12 November 2021

New Liverpool Primary School SSD – 10391

Response to Agency Submissions

NEW ROUNDABOUT

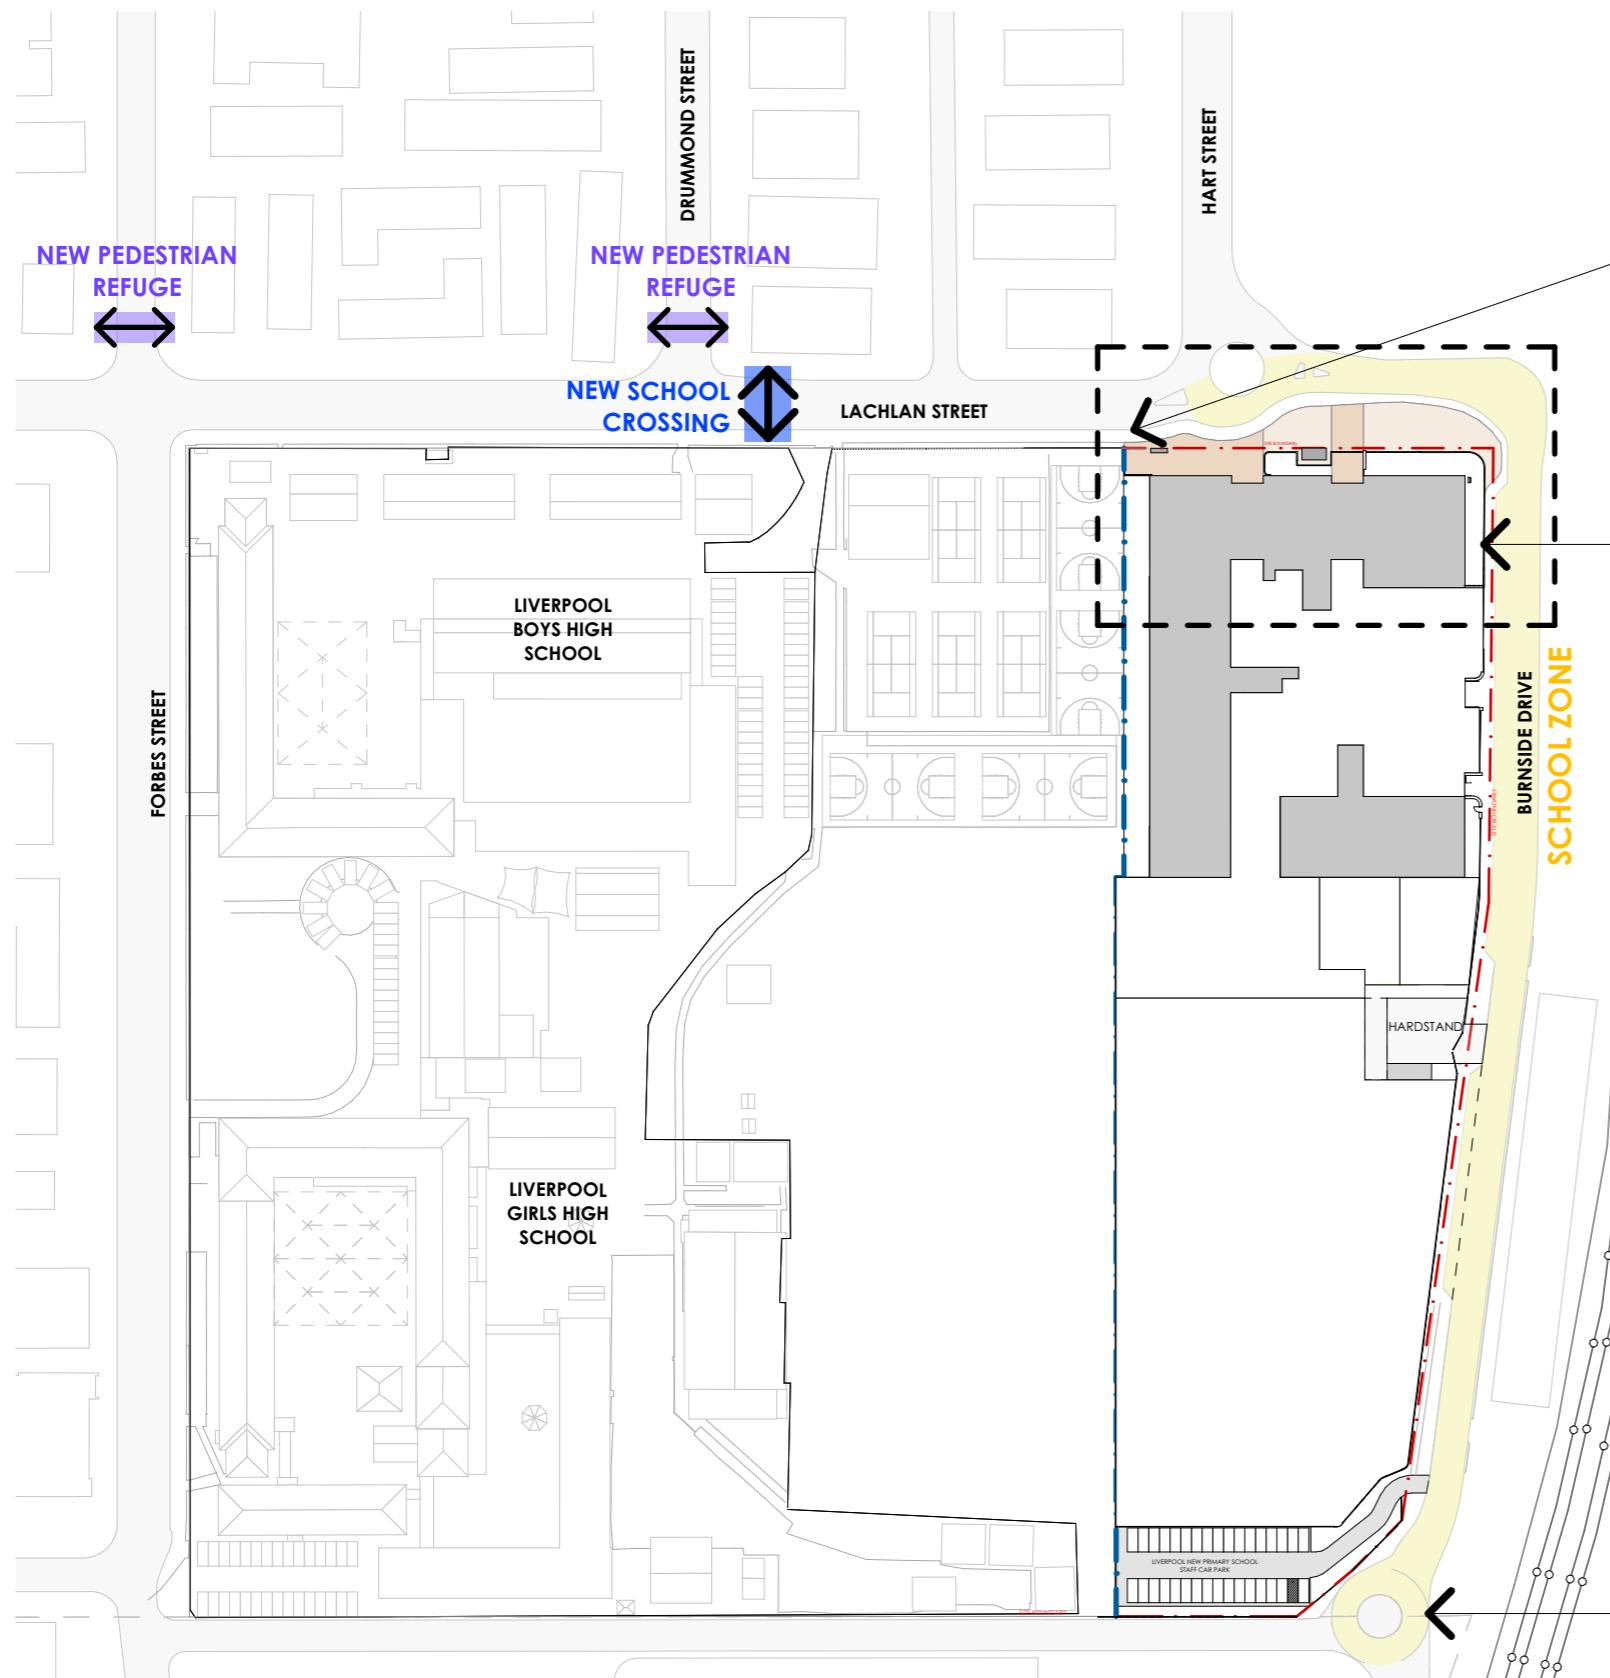
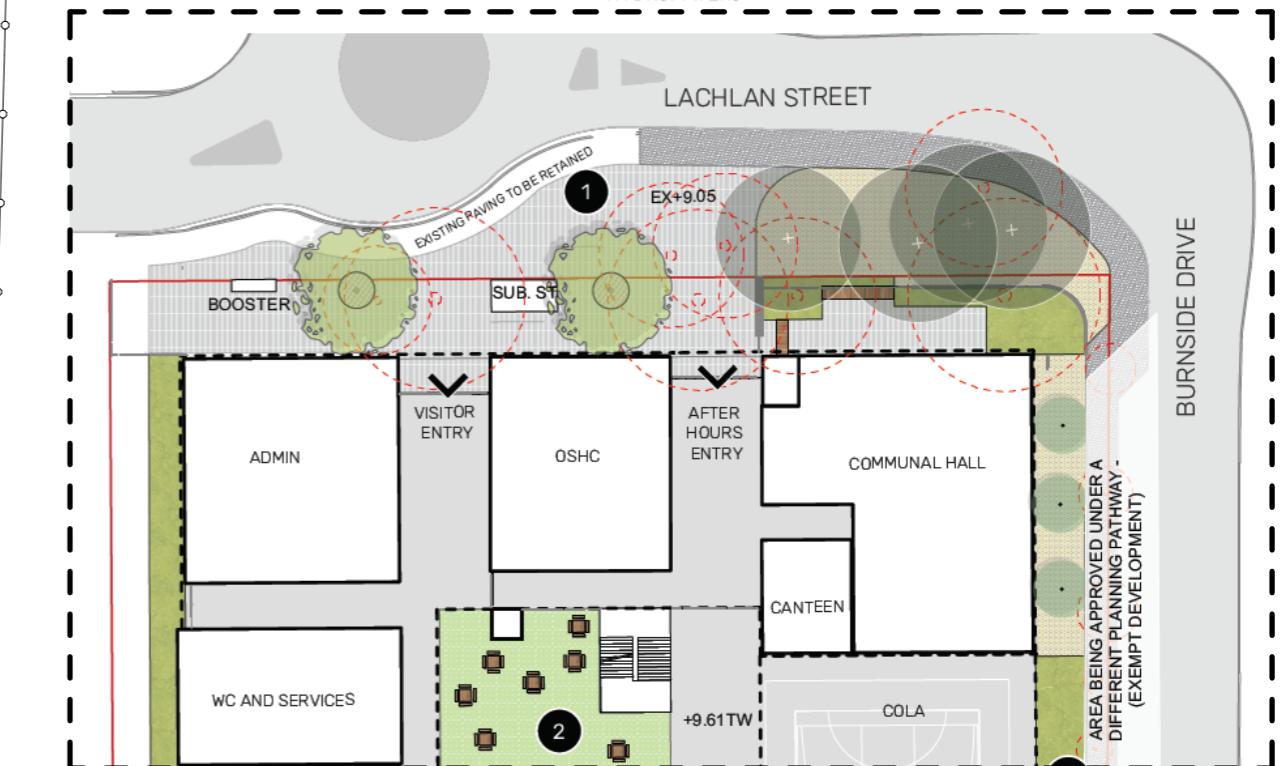
<ul style="list-style-type: none"> • the consultation process with SWAHD / TfNSW with regard to delivery of this roundabout. 	<p>Numerous consultation sessions have been undertaken with South West Sydney Local Health District, Health Infrastructure and School Infrastructure to discuss the delivery of the roundabout. This includes:</p> <ul style="list-style-type: none"> • 23 July – main discussion points; <ul style="list-style-type: none"> – Project Team presented the SSDA scope, noting exhibition dates for submissions to DPIE.

<ul style="list-style-type: none"> • whether any boundary adjustments would be needed as part of the school land appears to be utilised for the roundabout. 	<p>It is noted that the no boundary adjustments are needed.</p>
<ul style="list-style-type: none"> • whether the roundabout and the road infrastructure would be dedicated back to Council for future management. 	<p>The road is owned by the SWSLHD, and therefore the road will not be dedicated back to Council.</p>
<ul style="list-style-type: none"> • how would cars be prevented for making a U-turn on Burnside drive while dropping / picking students. 	<p>It is proposed that flexible bollards or pavement flaps will be utilised along the centreline of Burnside Drive to restrict U-turns. Further, additional marshals will be utilised at the beginning of each school year to educate users on the appropriate use of the school.</p>
<p>The Traffic Report states that, in order to ensure intersection performance improvements in 2033, an alternative physical mitigation measure may be proposed, which includes an additional short approach lane on the northern approach of the roundabout on Lachlan Street / Burnside Drive / Hart Street. Please confirm whether this mitigation measure is proposed to be pursued in 2033.</p>	<p>It is unlikely that this treatment is required and is presented as a contingency measure only, noting the modelled queuing without this treatment does not present any concerns. It will be pursued if no reduction in car mode share from the adjacent high schools or reduction in car mode share (from the base case) is achieved by NLPS.</p>

BURNSIDE DRIVE STREET LIGHTING
OVERALL PLAN
SCALE 1:500

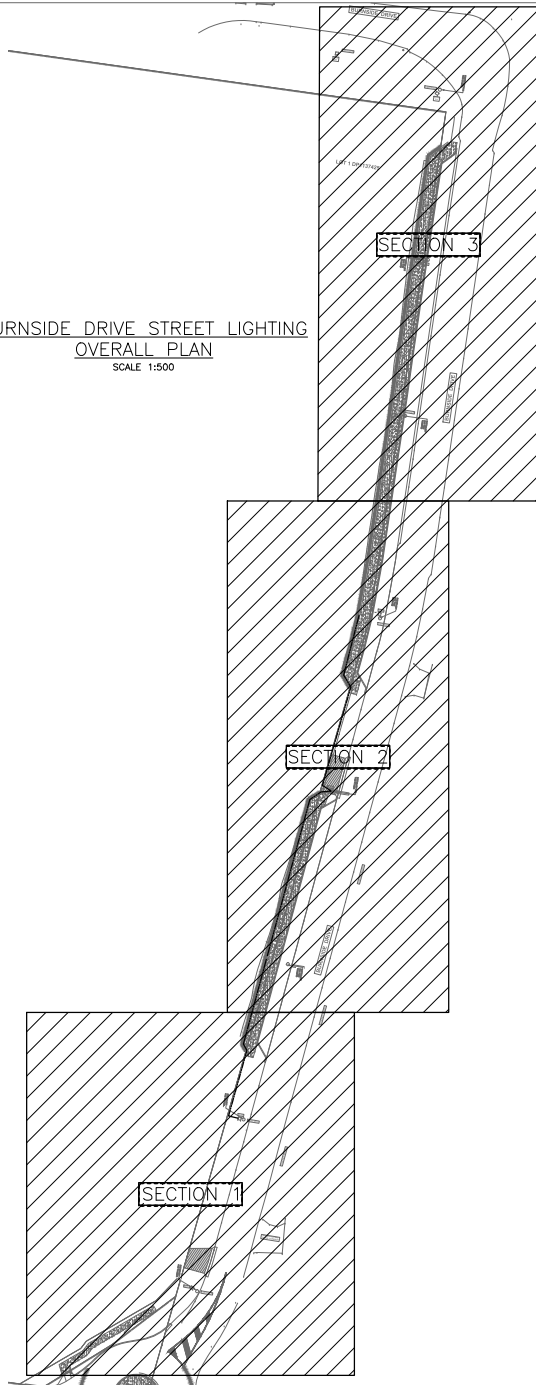
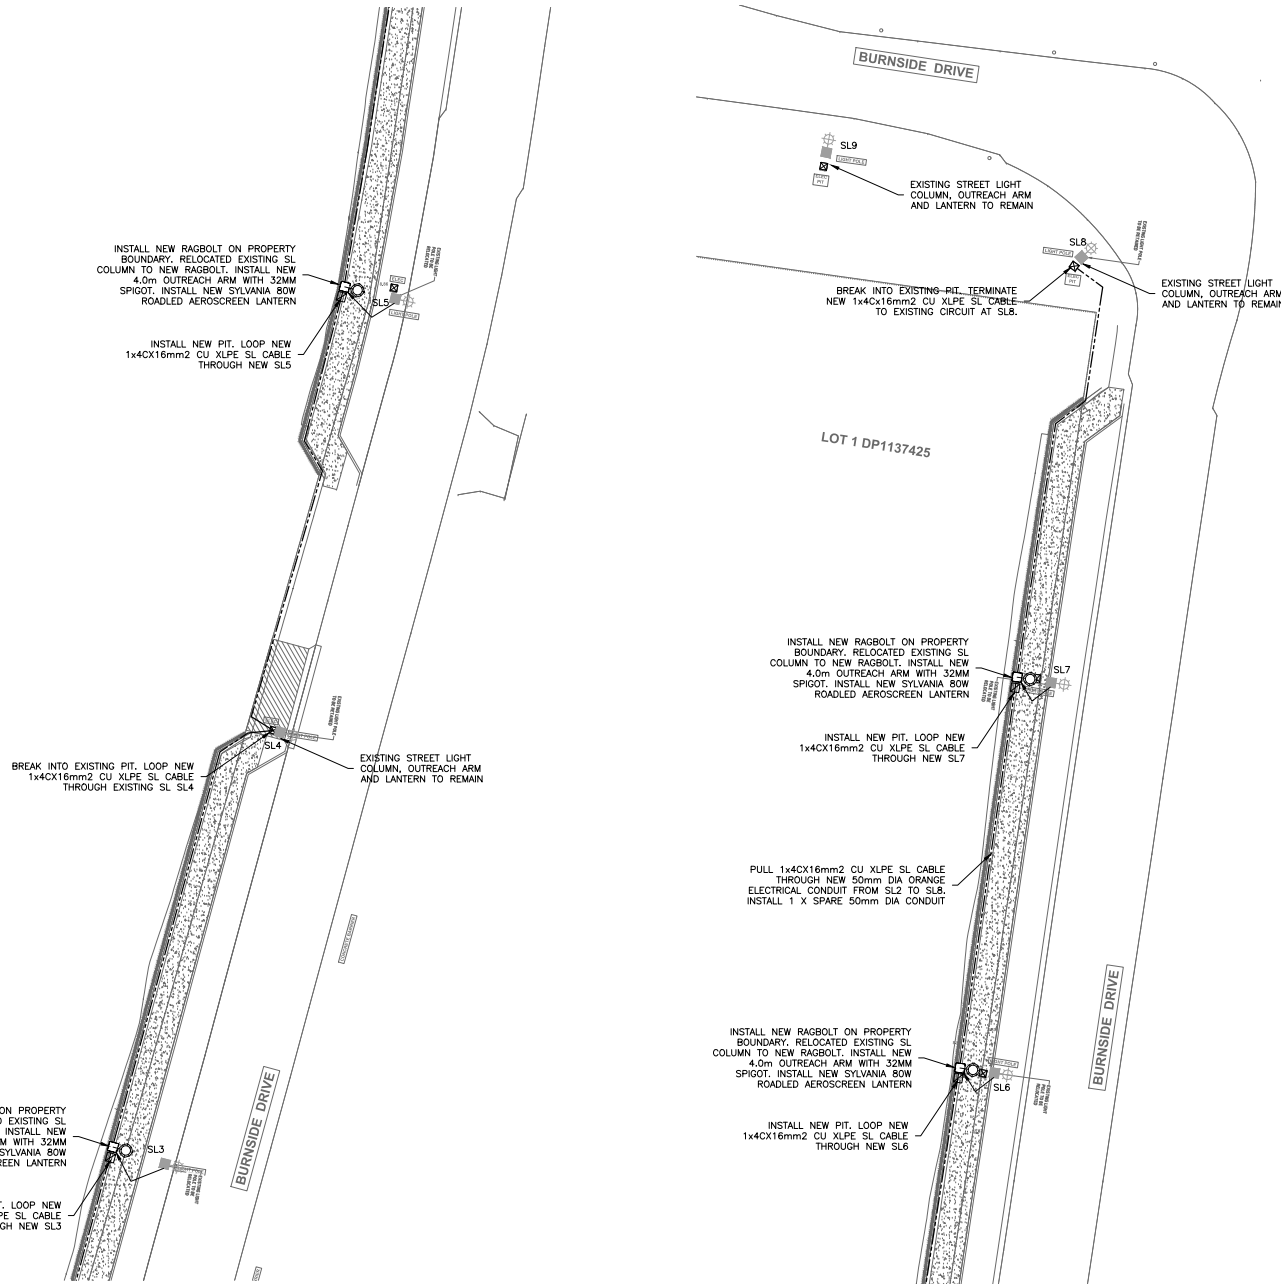
<p><u>Street Lighting</u> The applicant/developer shall engage the services of an Endeavour Energy accredited ASP Level 3 service provider to submit a Public Lighting Design Brief to Council's Traffic and Transport Section, to specify design requirements to upgrade the street lighting system along the frontage of the development site, including any side streets.</p> <p>The upgrade shall include undergrounding of existing aerial power lines and communication cables and replacement of existing streetlight poles with multifunction poles, and all</p>	<p>Noted. Recommended conditions of consent will be considered by the Department at the determination stage. SINSW will comment further on these conditions once conditions have been drafted.</p>
